PLANNING BOARD REPORT PORTLAND, MAINE

7-unit Condominium Development
30 Merrill Street
Level III Site Plan and Subdivision Review
2016-172
Banner Properties, LLC

Submitted to: Portland Planning Board Date: October 7, 2016 Public Hearing Date: October 12, 2016	Prepared by: Nell Donaldson, Planner CBL: 014 C 14 Project #: 2016-172
---	--

PROJECT NAME: SIX-UNIT BUILDING 30 MERRILL STREET
 PORTLAND, MAINE
 SHEET NAME: SITE LAYOUT PLAN

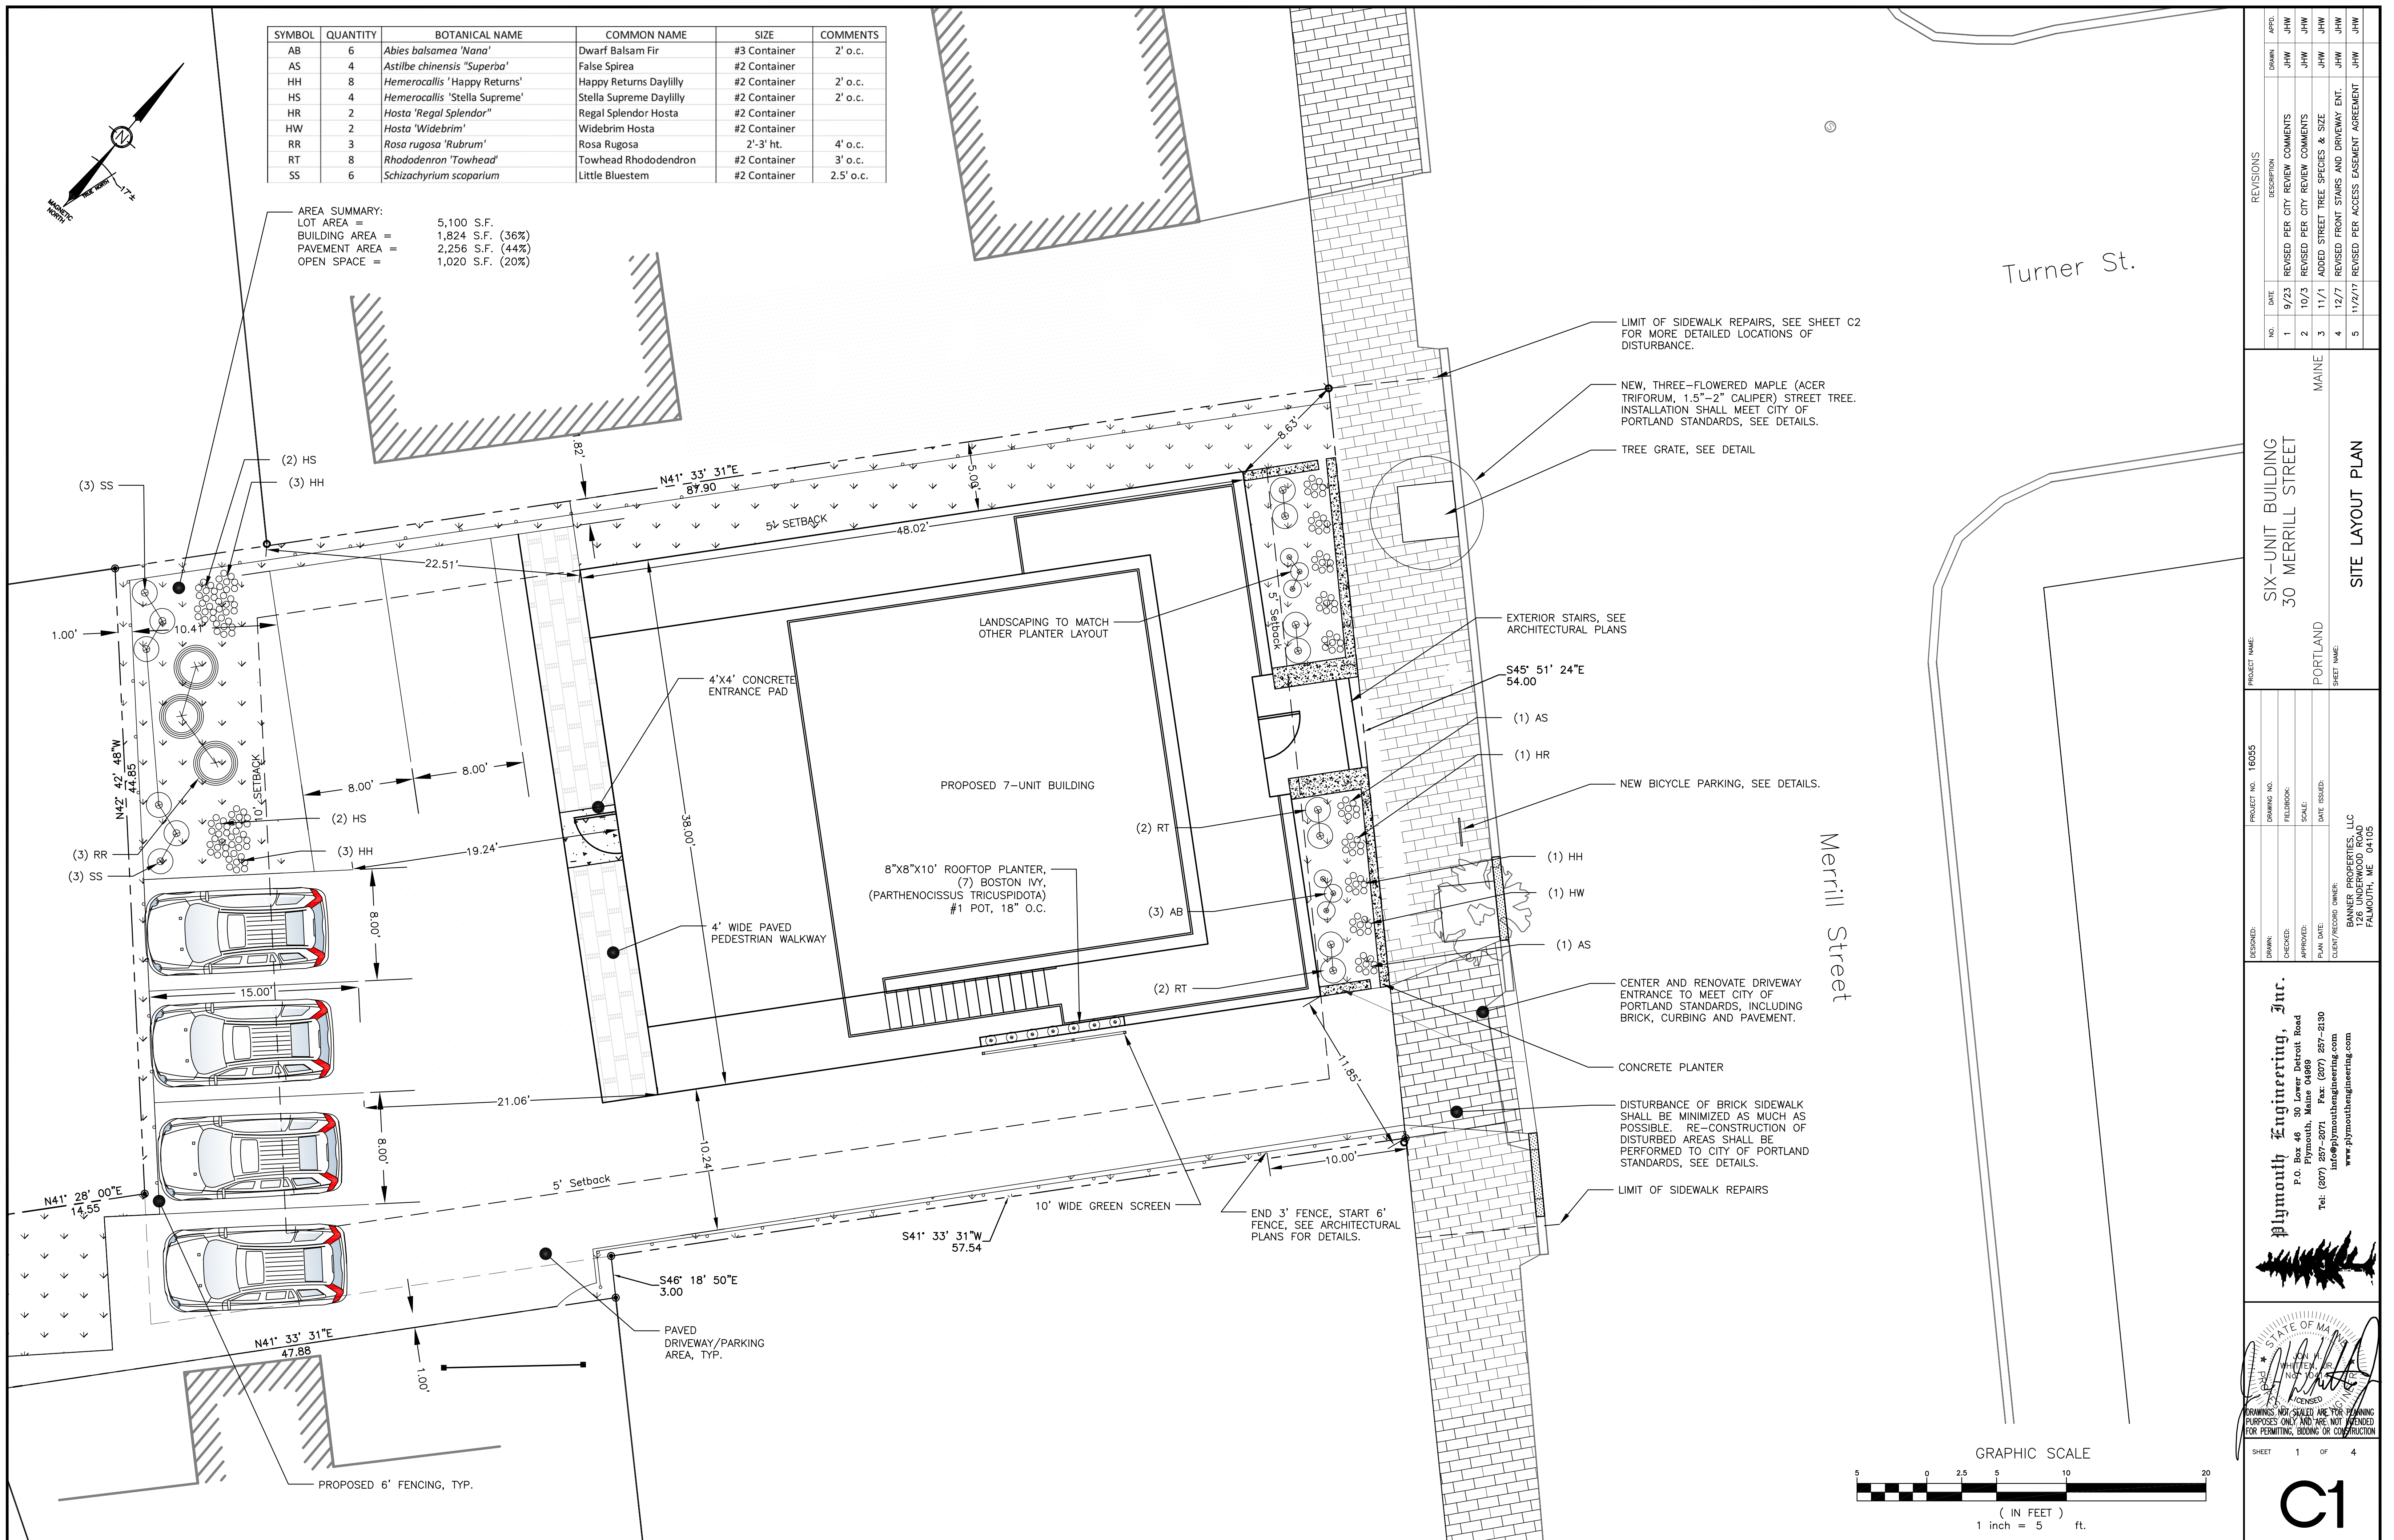
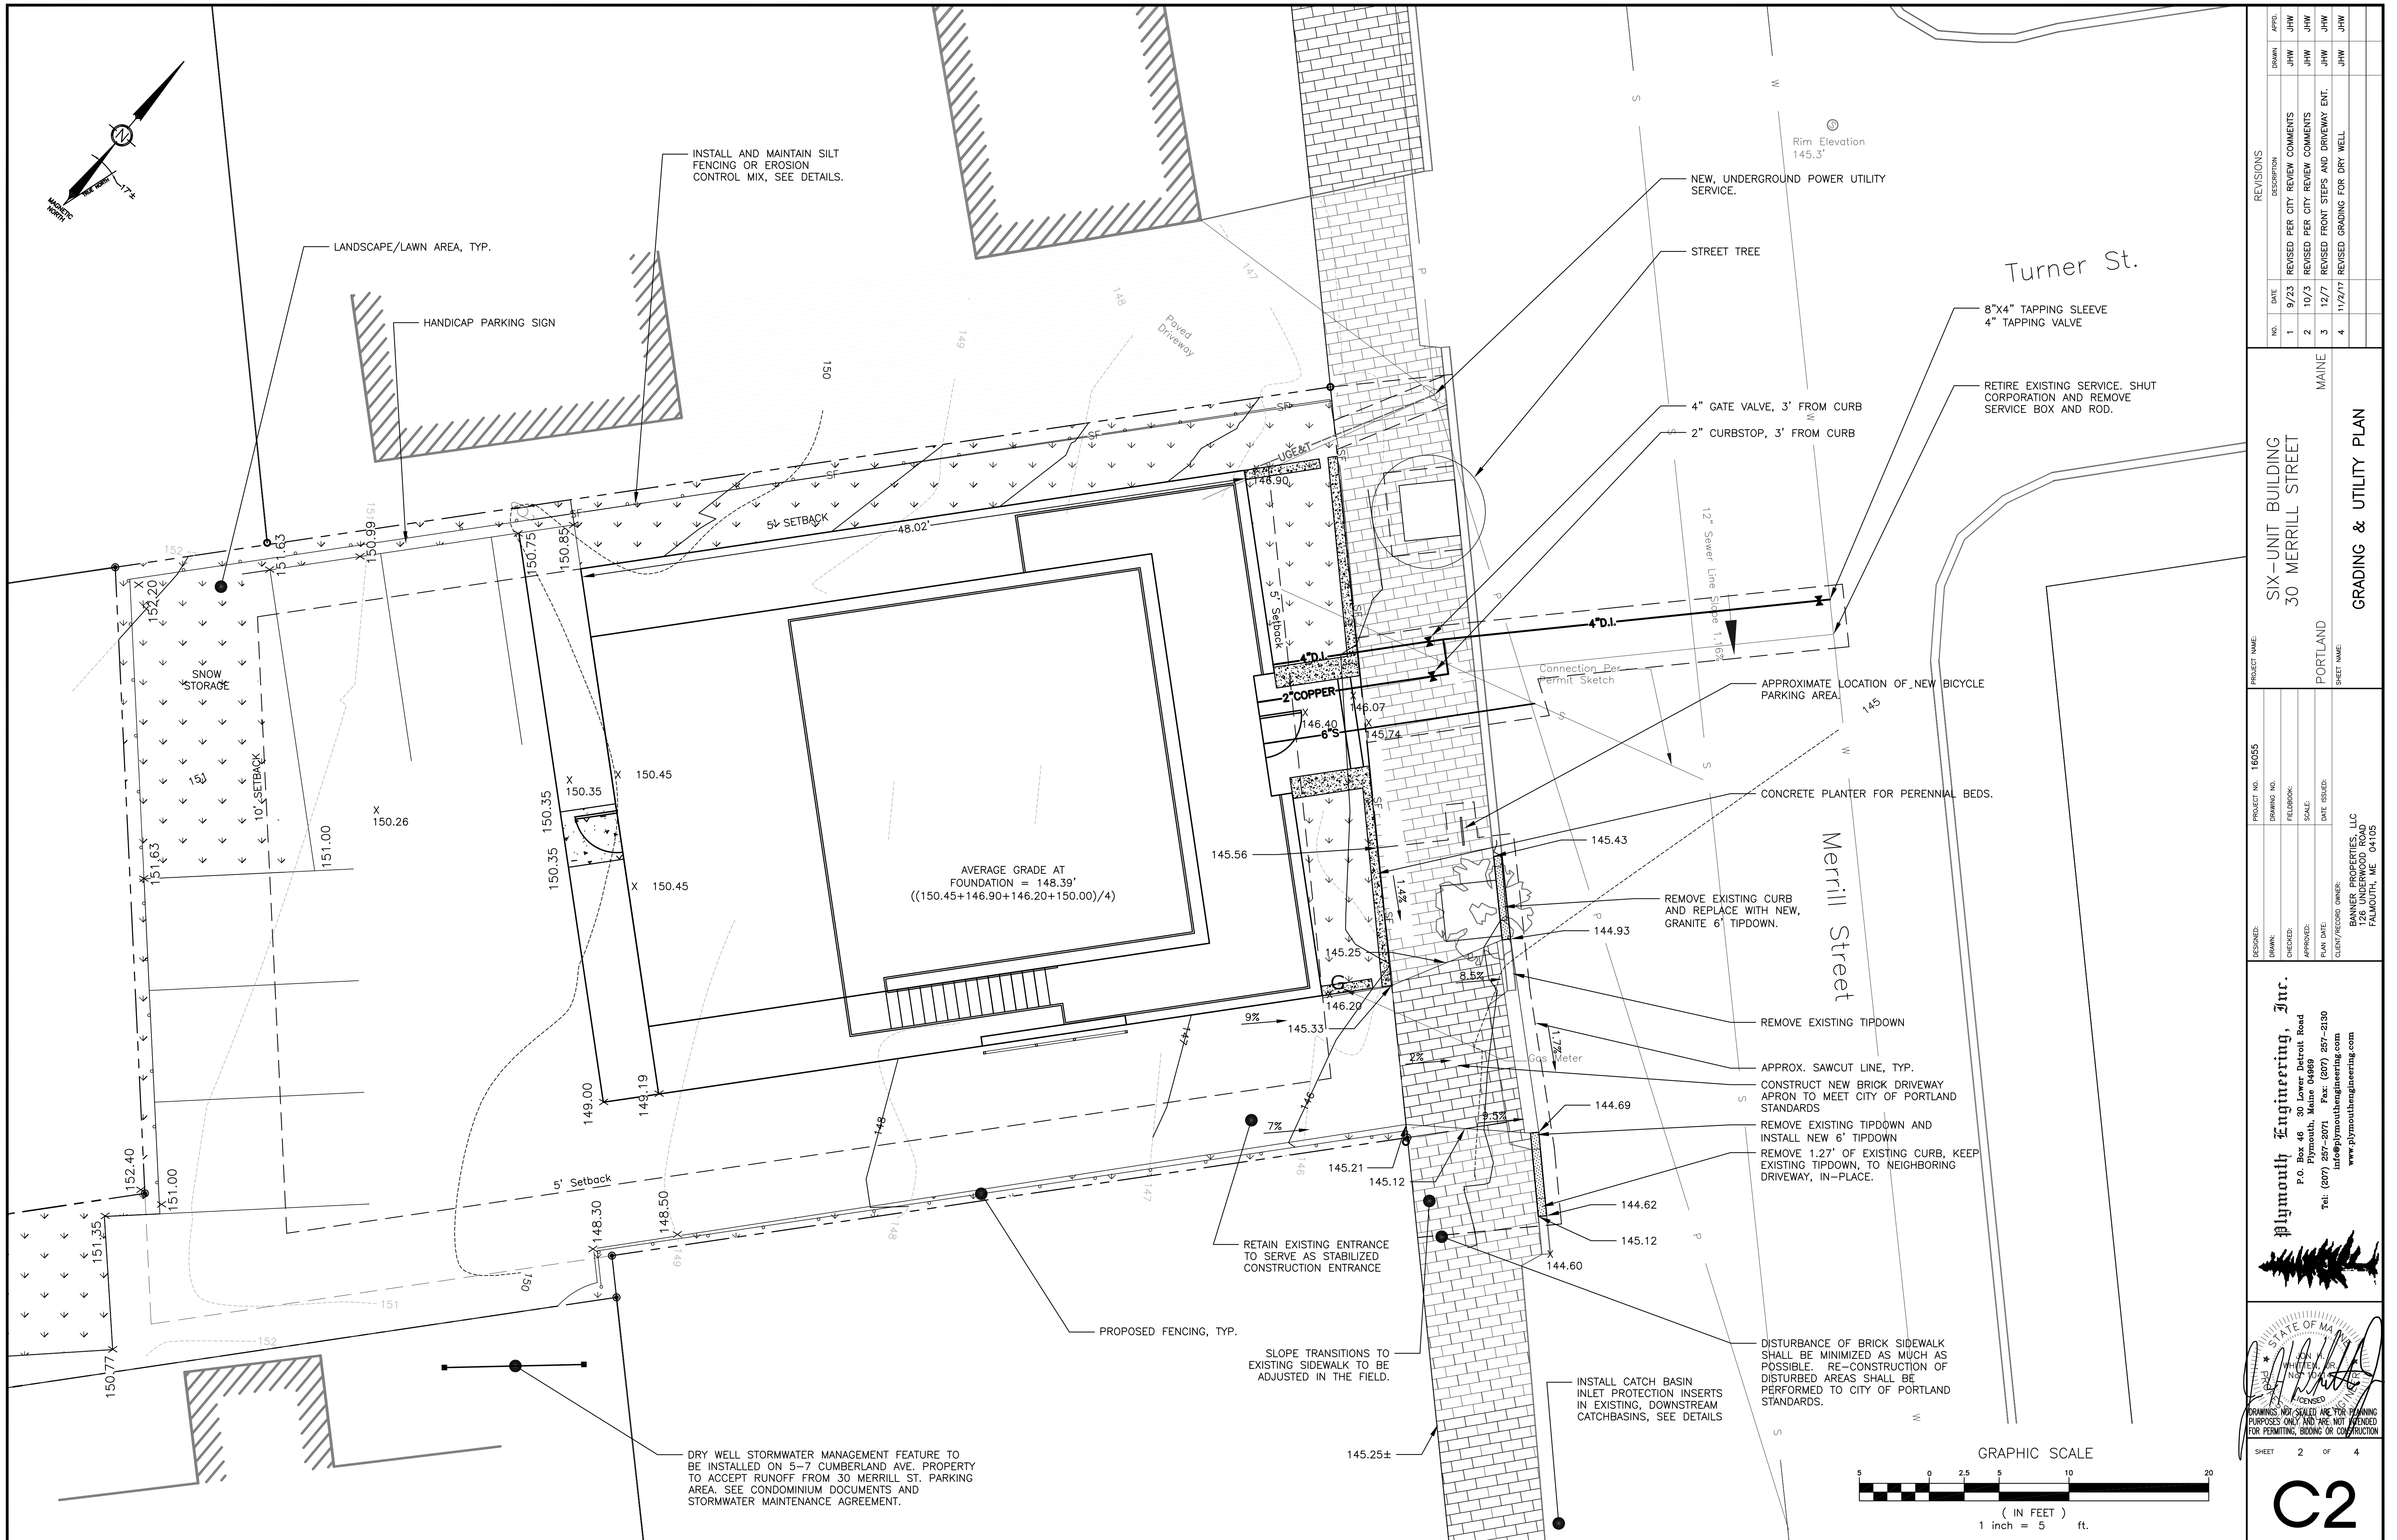
The final plans include utility, street tree, and driveway apron work within the existing 8’ brick sidewalk along the frontage of the site. Given the amount of work proposed in the sidewalk, the Department of Public Works has requested that the sidewalk be replaced in its entirety. Mr. Errico writes,

Based upon disruption of the existing sidewalk due to utility connections, driveway apron improvements, and general construction activity, DPW requires full replacement of the existing sidewalk along the project frontage.

The new curb cut is proposed with a brick apron. Asphalt aprons are standard in this area of the city, although the City Council has recently adopted a policy to provide for consistent sidewalk material across driveway openings. A condition of approval has been drafted to address this situation. As Mr. Errico writes,

The plans have been revised to note that the driveway apron will be upgraded and centered with the proposed driveway. The plan notes a brick driveway apron and I would suggest a condition of approval that requires the project meet driveway design material standards currently being considered for revision by the City Council.

The plans show a driveway in pervious pavers which would provide access to five parking spaces, one of which would be accessible. The drive aisle in the parking area proposed at less than 19’, less than the city standard. As such, a waiver is required. At Mr. Errico’s request, the applicant has provided turning templates in an effort to document the efficacy of the parking circulation. Mr. Errico has reviewed the turning templates and supports a waiver for aisle width (*Attachment 3*).

It should be noted that Mr. Errico has raised some concerns regarding a fence that is proposed along the eastern property line, particularly where it may conflict with sight distances to the adjacent driveway. He writes,

The applicant has provided a fence detail that I find to be acceptable. Given that backing maneuvers are likely, I would suggest that the fence height be reduced to 3.5 feet for the first fence panel from the property line to ensure safe sight lines to pedestrians on the sidewalk.

This has been included as a condition of approval.

This has been included as a condition of approval.
